## **BCA Assessment Report**

**Building 5, Interlink Industrial Estate  
Mamre Road, Erskine Park**

**Goodman Property Services (Aust) Pty Ltd**

31 October 2011

INT DA601 (G)

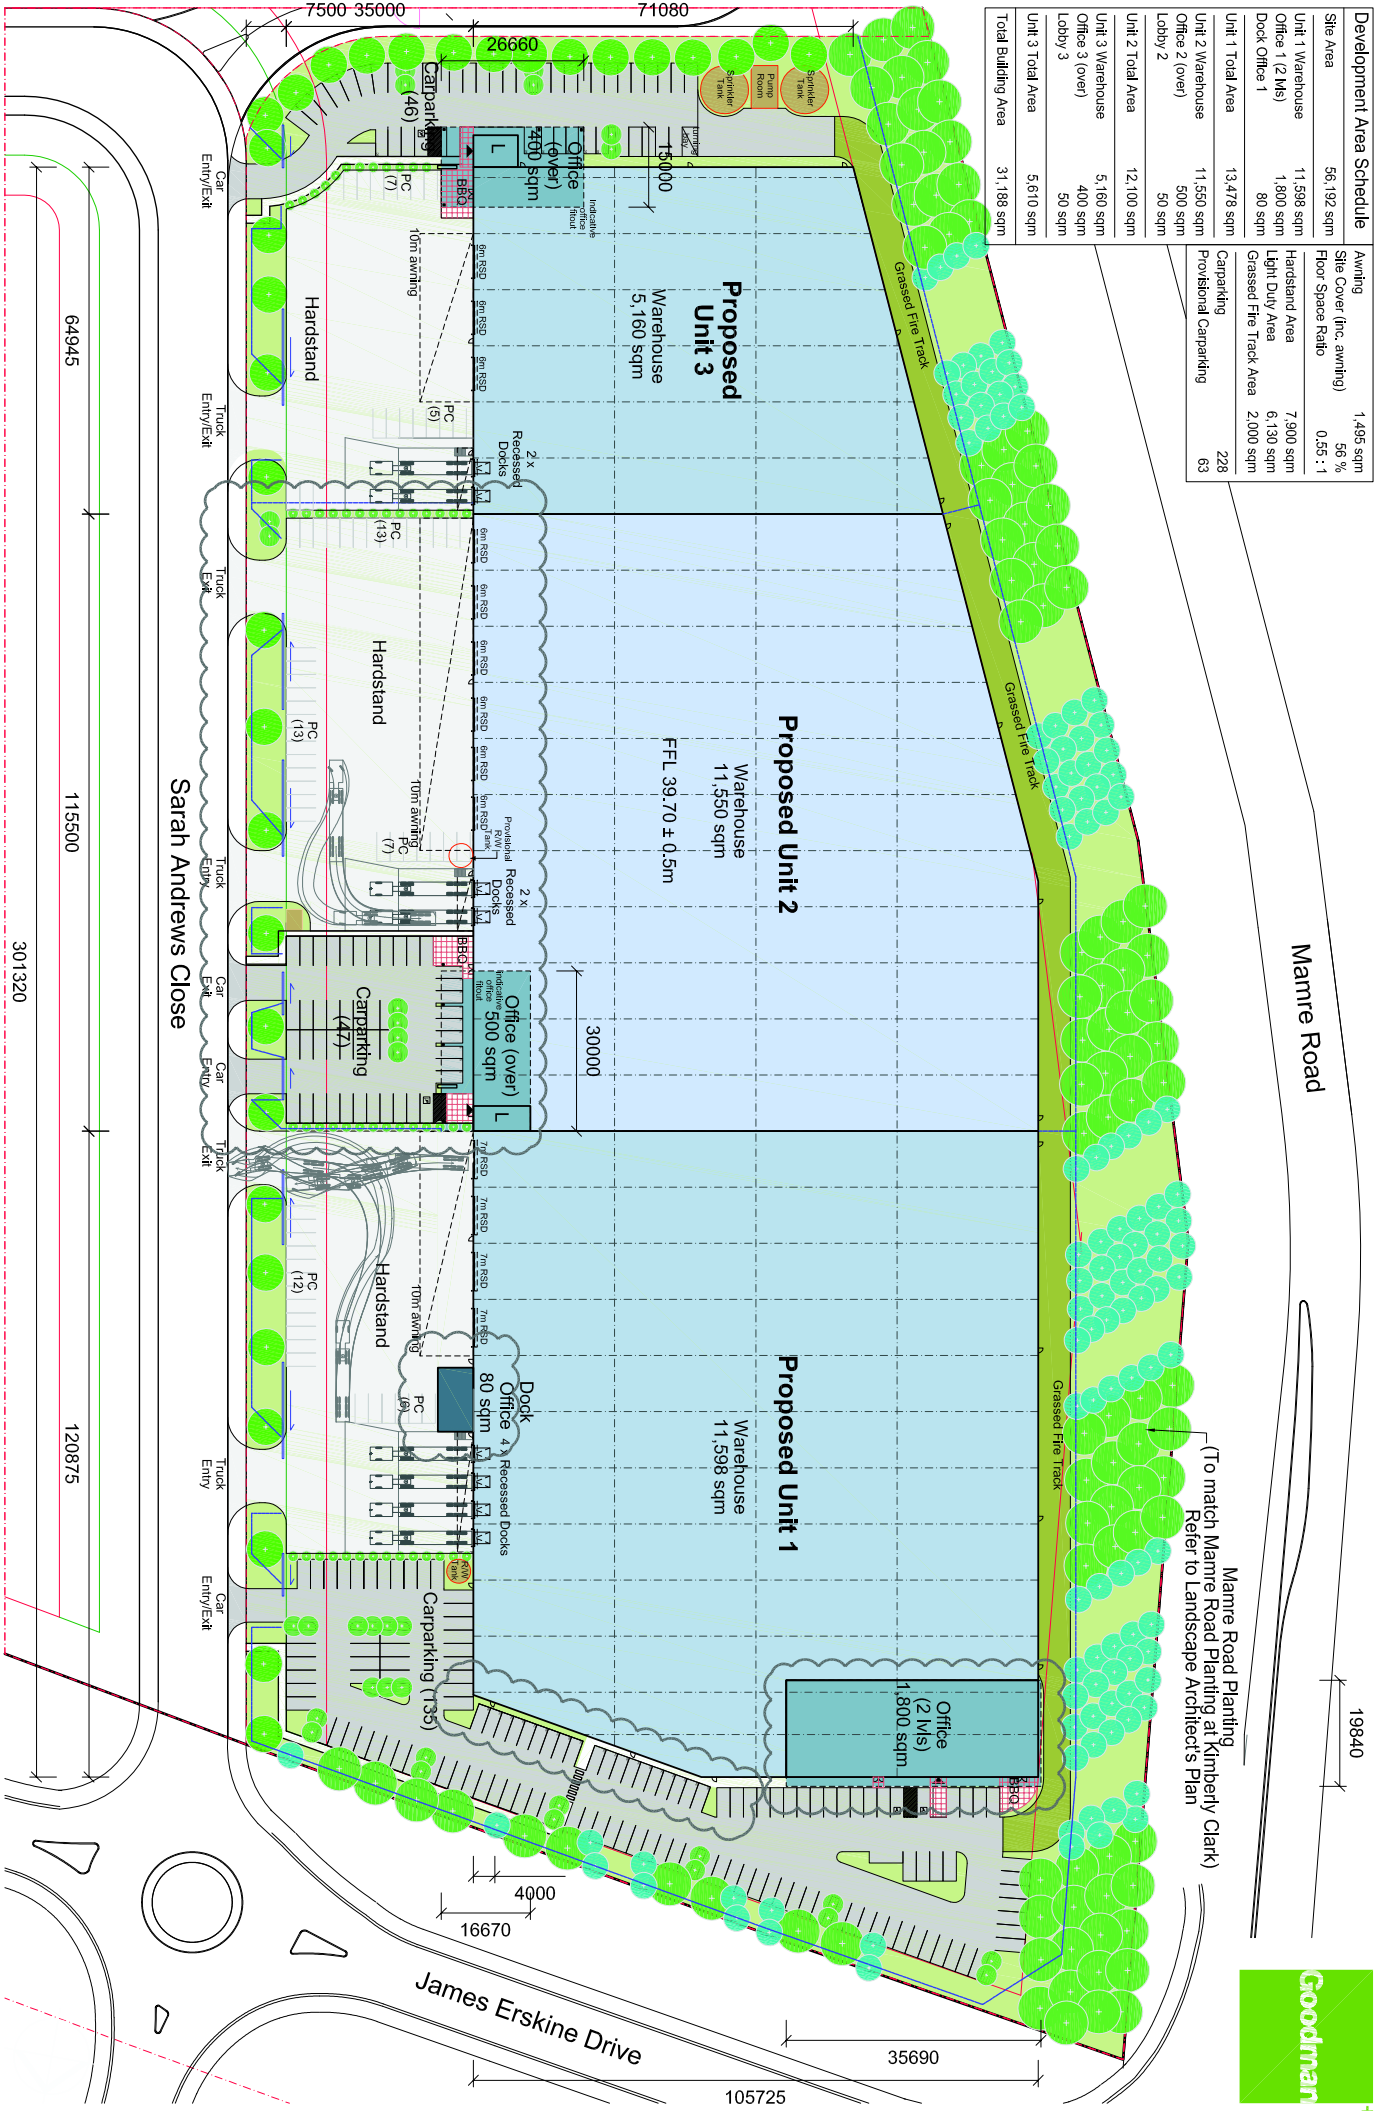
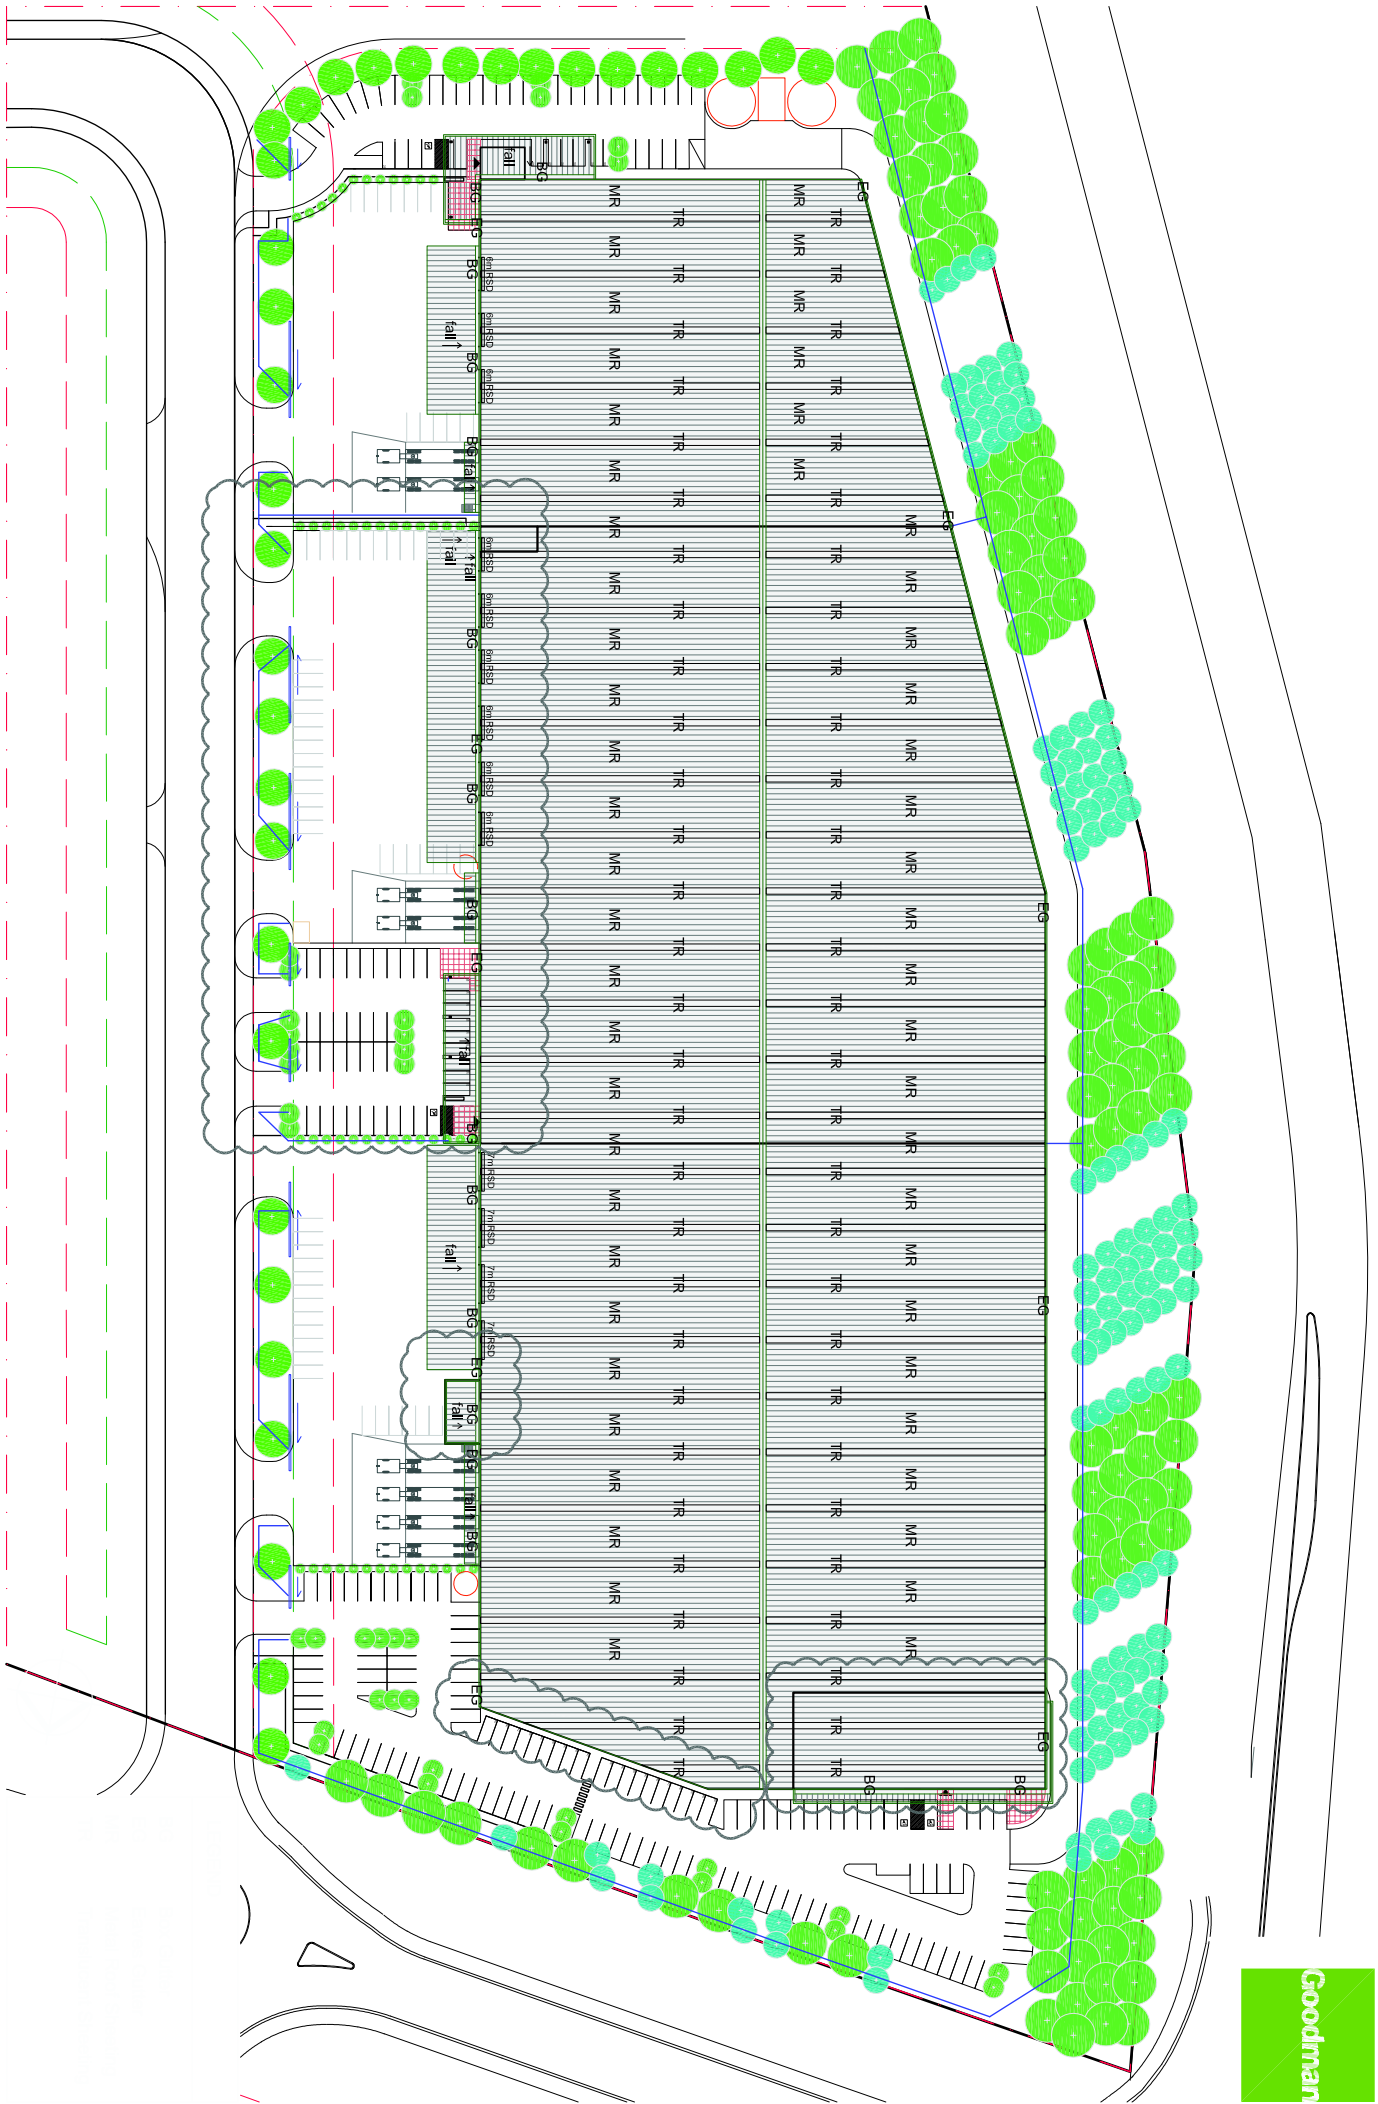
5. BCA cl. C2.4 Requirements for Open Spaces and Vehicular Access: A minimum unobstructed width of 6m is required around the building for fire brigades perimeter vehicular access with no part of its furthest boundary more than 18m from the building. Furthermore, vehicular access must have a load bearing capacity and unobstructed height to permit the operation and passage of fire brigade vehicles, and must provide reasonable pedestrian access from the vehicular access to the building. Note: Where the construction of the building is to be staged, a temporary vehicular access road is to be provided along the southern side of Unit 1 of until such time as the next stage of the project is constructed.

The following compliance issues have been identified with respect to the proposed perimeter vehicular access serving the subject development:

- a) Vehicular access is discontinuous at the north-eastern and south-eastern corners of the building, due to carpark configuration and division to the hardstand.
- b) Vehicular access is provided on the eastern side of the building via Sarah Andrews Close – this vehicular access is greater than 18m from the external wall of the building and as such is non-compliant.
- c) In the case where the construction of the building will be staged, the temporary vehicular access on the southern side of Unit 1 will be unavailable during the construction of the following stage.

It will be necessary for an alternative solution to be prepared to address these non-compliance issues, in order to demonstrate compliance with Performance Requirement CP9.
